Our ref: 41 College Road

Re: Proposed minor material amendment under the provisions of Section 73 of The Town and Country Planning Act 1990, as amended.

Amendment to condition 1 to allow a Minor Material Amendment comprising a change to boundary landscaping and the position of the drive to match Dulwich Estate requirements. Also, a slight change to the garden boundary within the overall application site.

41 College Road, London. SE21 7BA

DWG Ref: LSD/060123 Rev: B

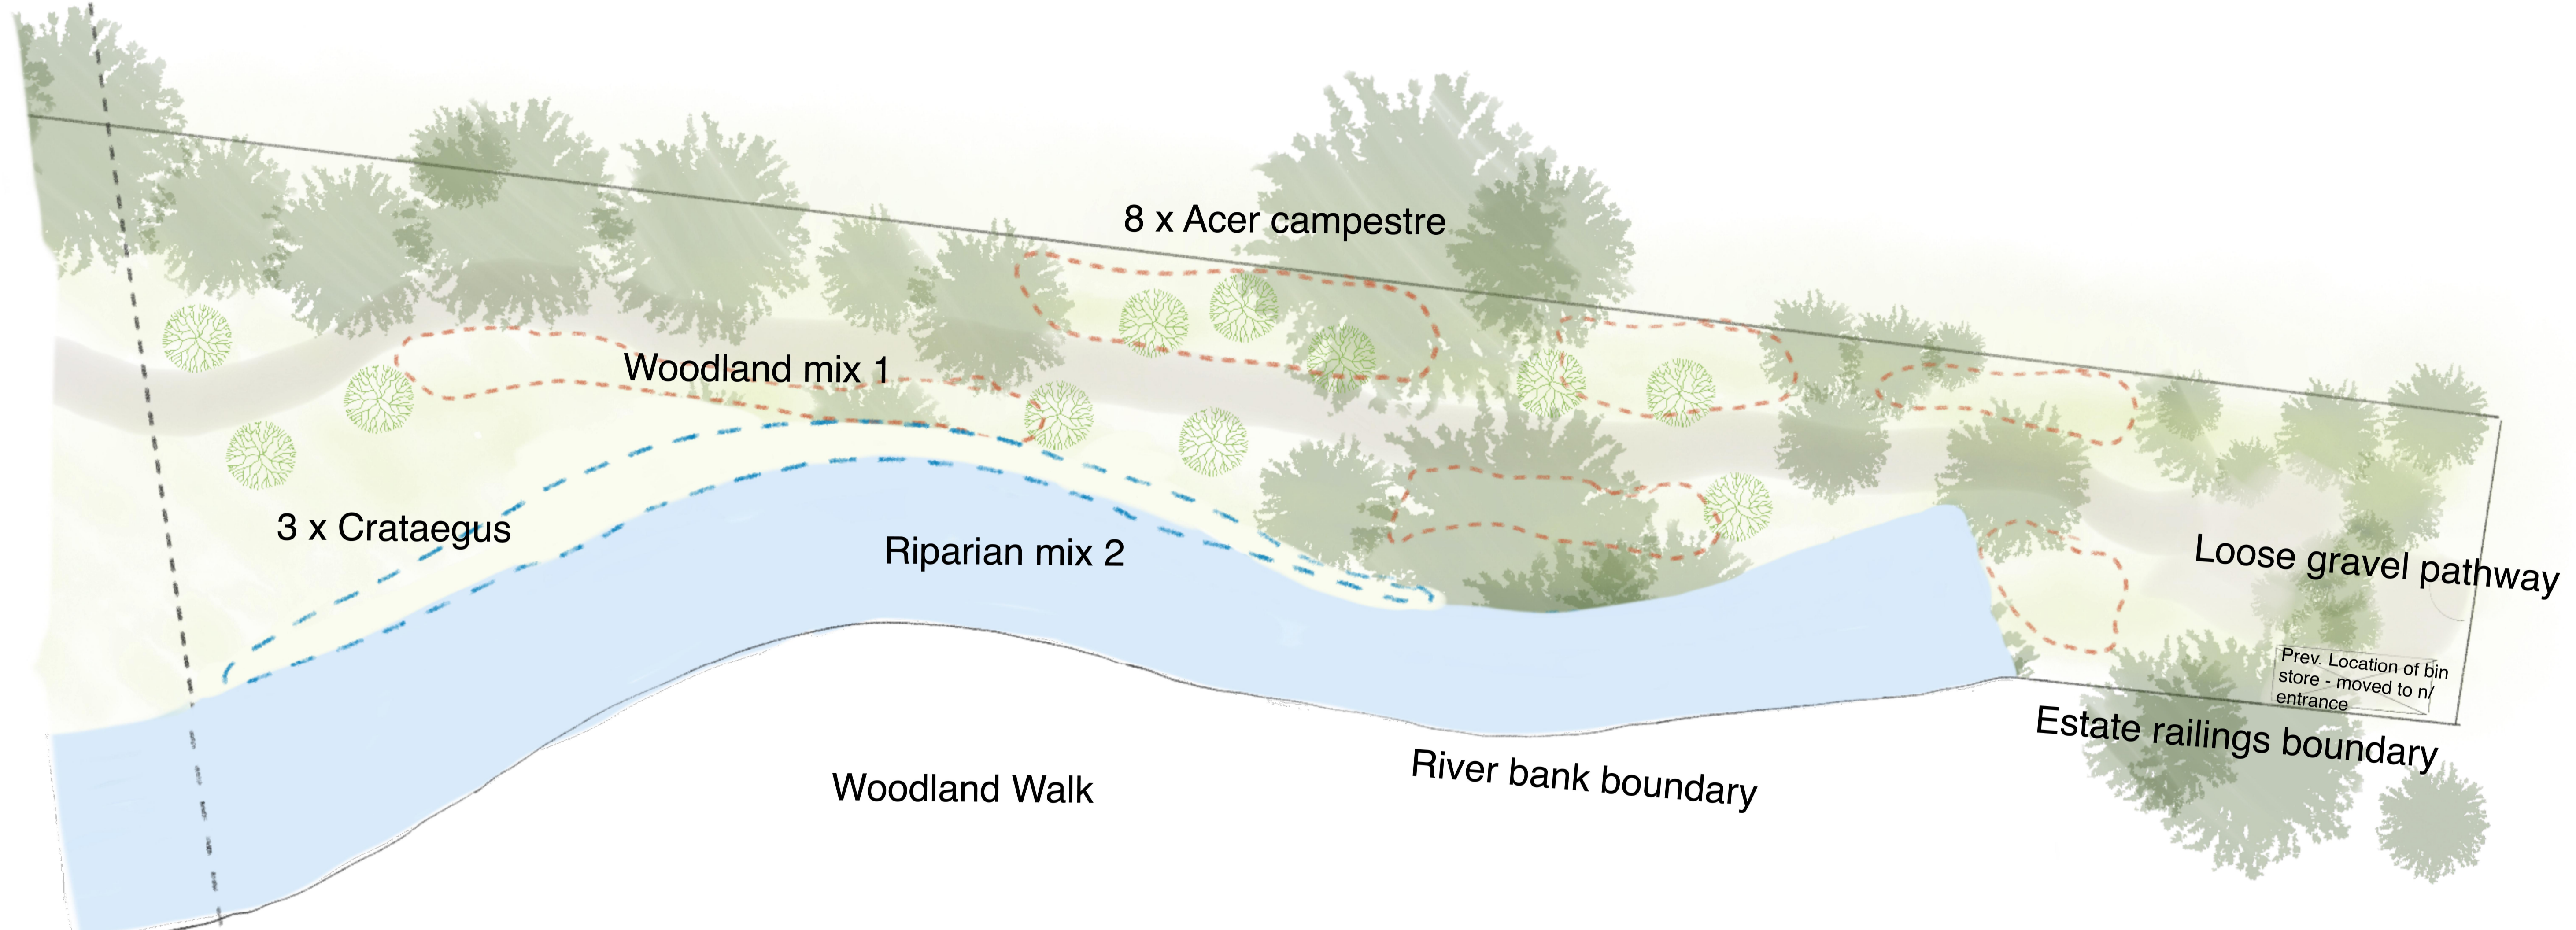
- Drawing No 41COLL PL15
Location Plan showing the garden boundary within the wider application site.
(A new drawing).
- Drawing No 41COLL LP29 Rev C
Site plan showing the revised driveway. (replacing approved drawing 41COLL LP21)
- Drawing No LSD/060122 Rev I
Landscape Masterplan (replacing LSD/060122 Rev D)

- Drawing No LSD/060123 Rev B
Landscape Masterplan (replacing LSD/060123 Rev A)
- WLA/2223/01 AMS dated 07/12/2023.
Arboricultural Report and Arboricultural Method Statement (updated to replace earlier version dated 26/01/2023)
- Drawing No WLA/2223/01 Rev C
Tree constraints plan and Arboricultural method statement. (updated to replace Rev B)
- Copy of planning permission 23/AP/0353 dated 03/05/2023.
- Copy of drawing No 41COLL LP29 Rev B with notes added to explain the changes to the landscaping and drive position required by The Dulwich Estate.
- Supporting information within this letter.

Client: Thompson Family
 Project: 41 College Road, Dulwich
 Title: TREE CONSTRAINTS PLAN, PROTECTION PLAN & METHOD STATEMENT
 Date: 08/12/23 Scale: 1: 200 @ A1 (CHECK PRINTER SPEC)
 Drawn: MW Checked: PW Client Ref:
 Drawing Number: WLA/2223/01
 Rev: C

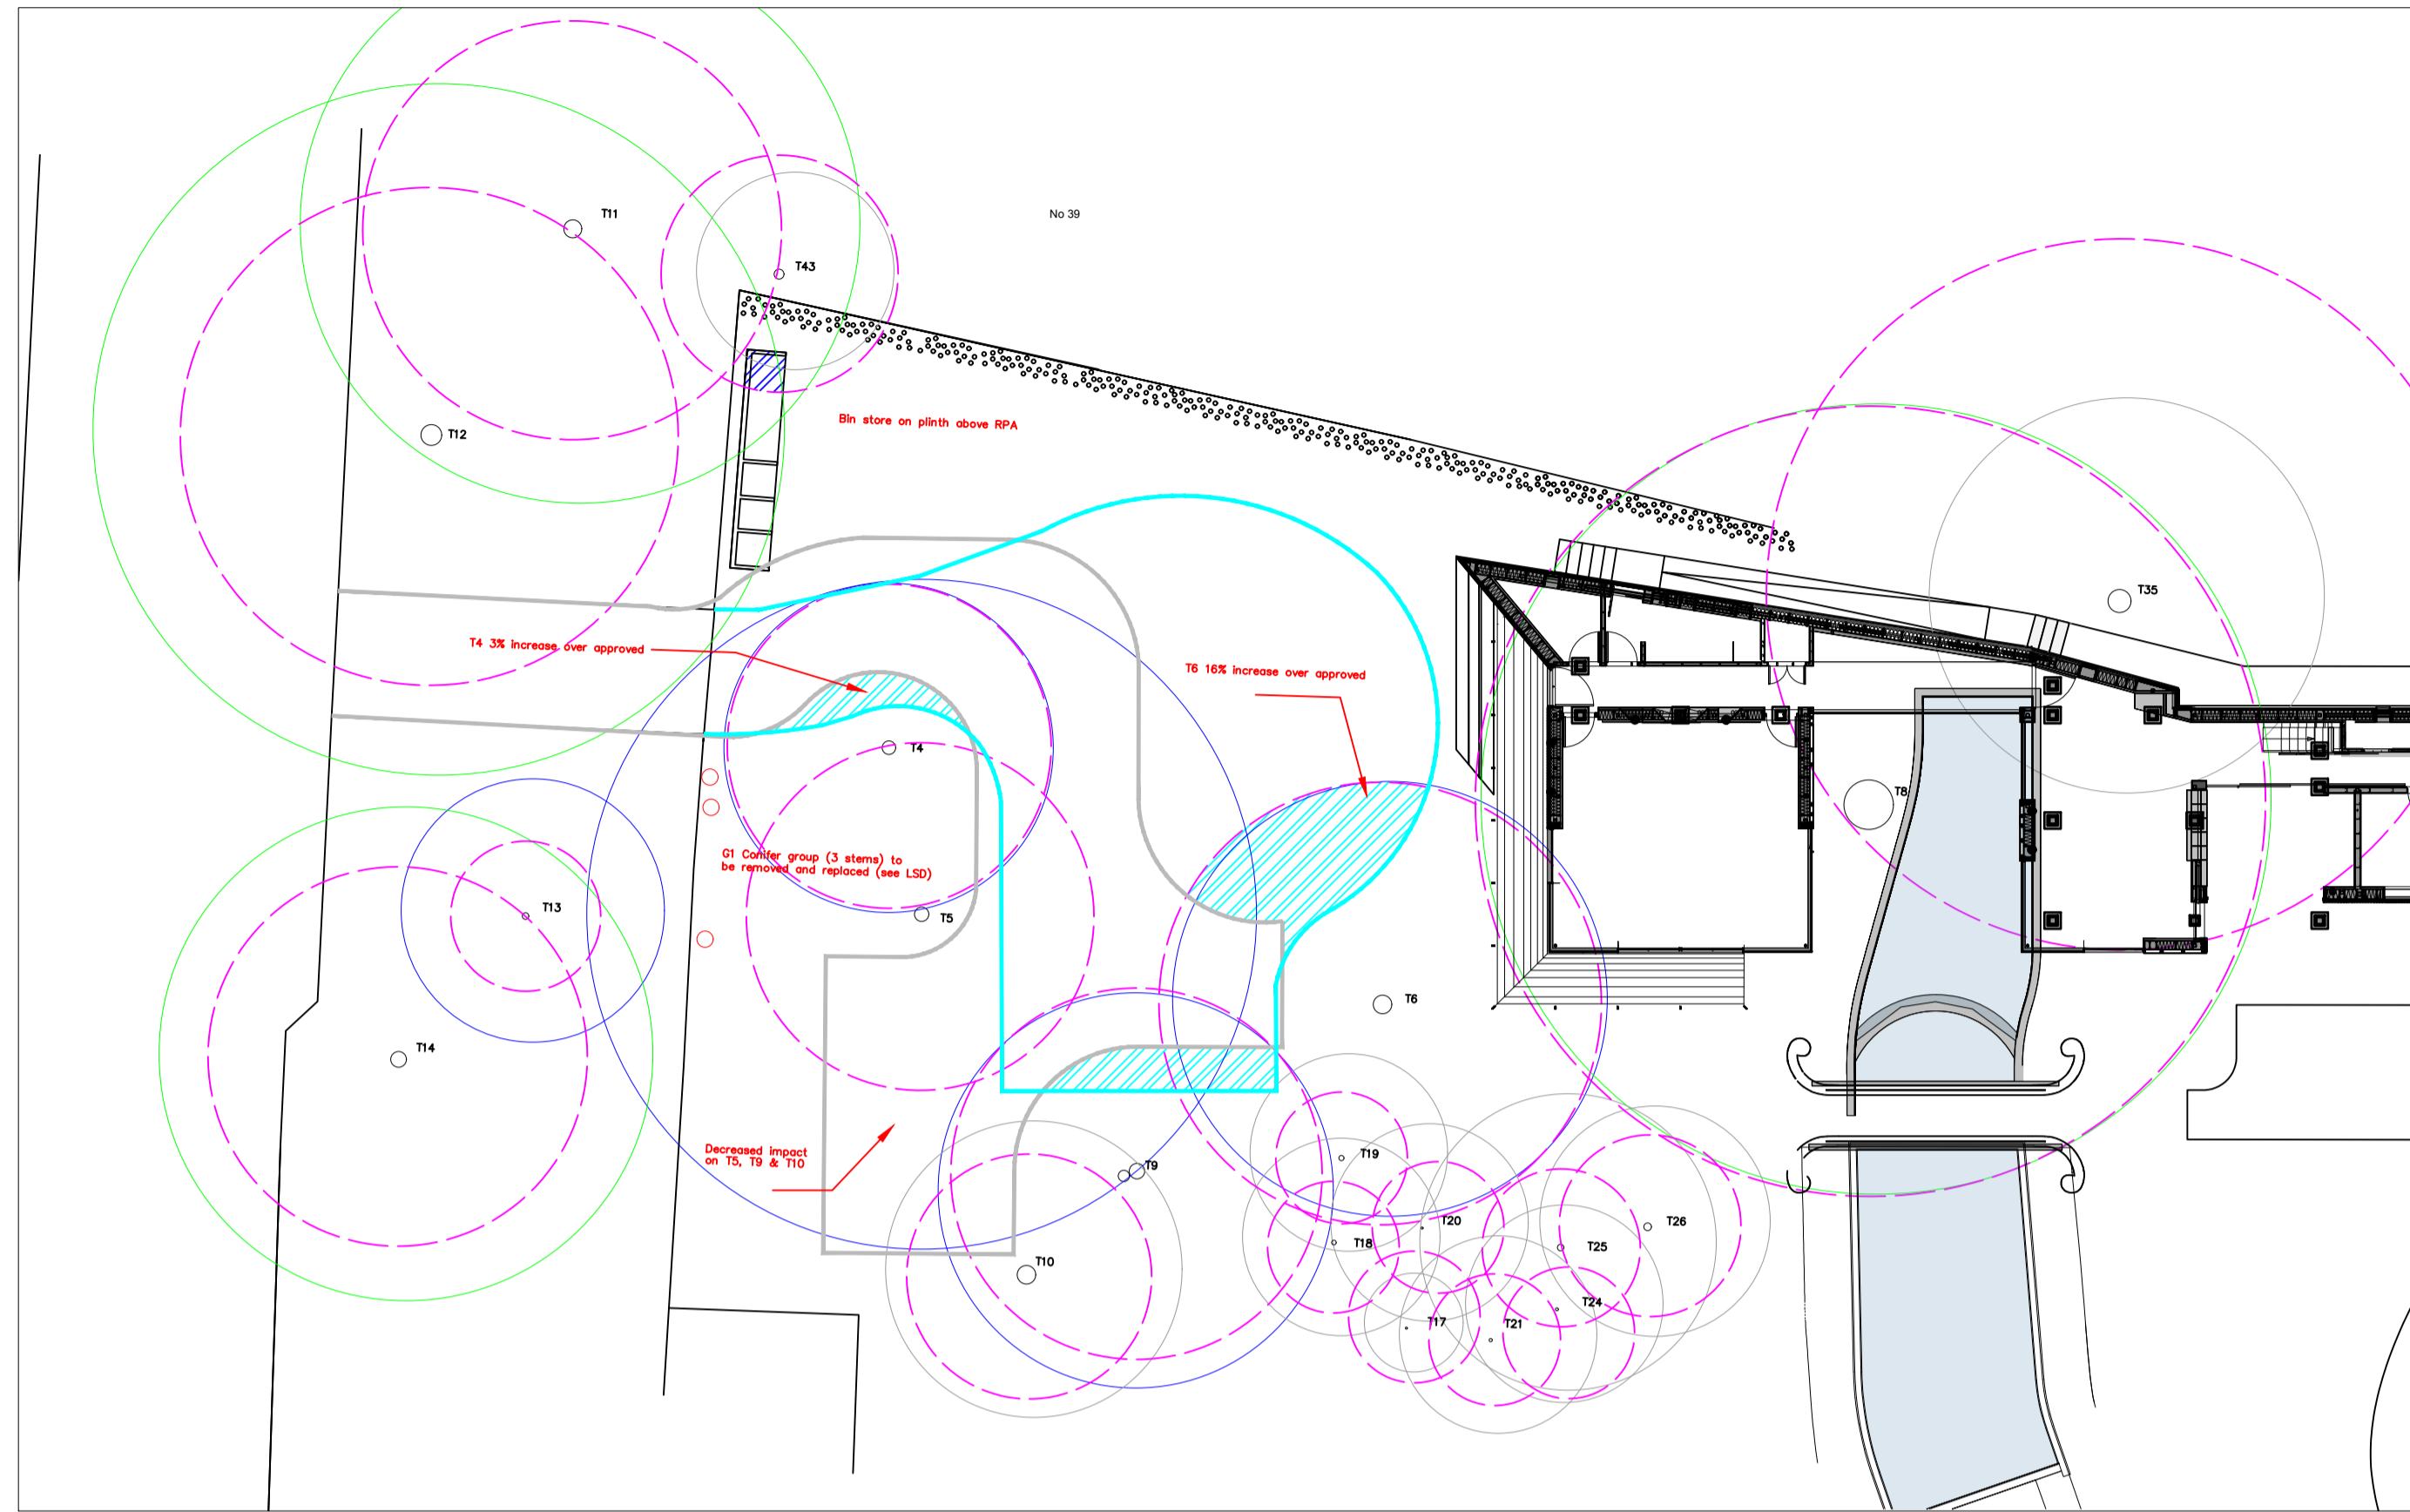
- The addition of an oak pleached hedge to provide all year-round screening between No 36 and 41 College Road.
- Three new Picea Omorica (Siberian Spruce) trees to provide all year-round screening from Collage Road.
- A change in the position of the drive to be moved 1m to the south, away from the boundary with No 36.
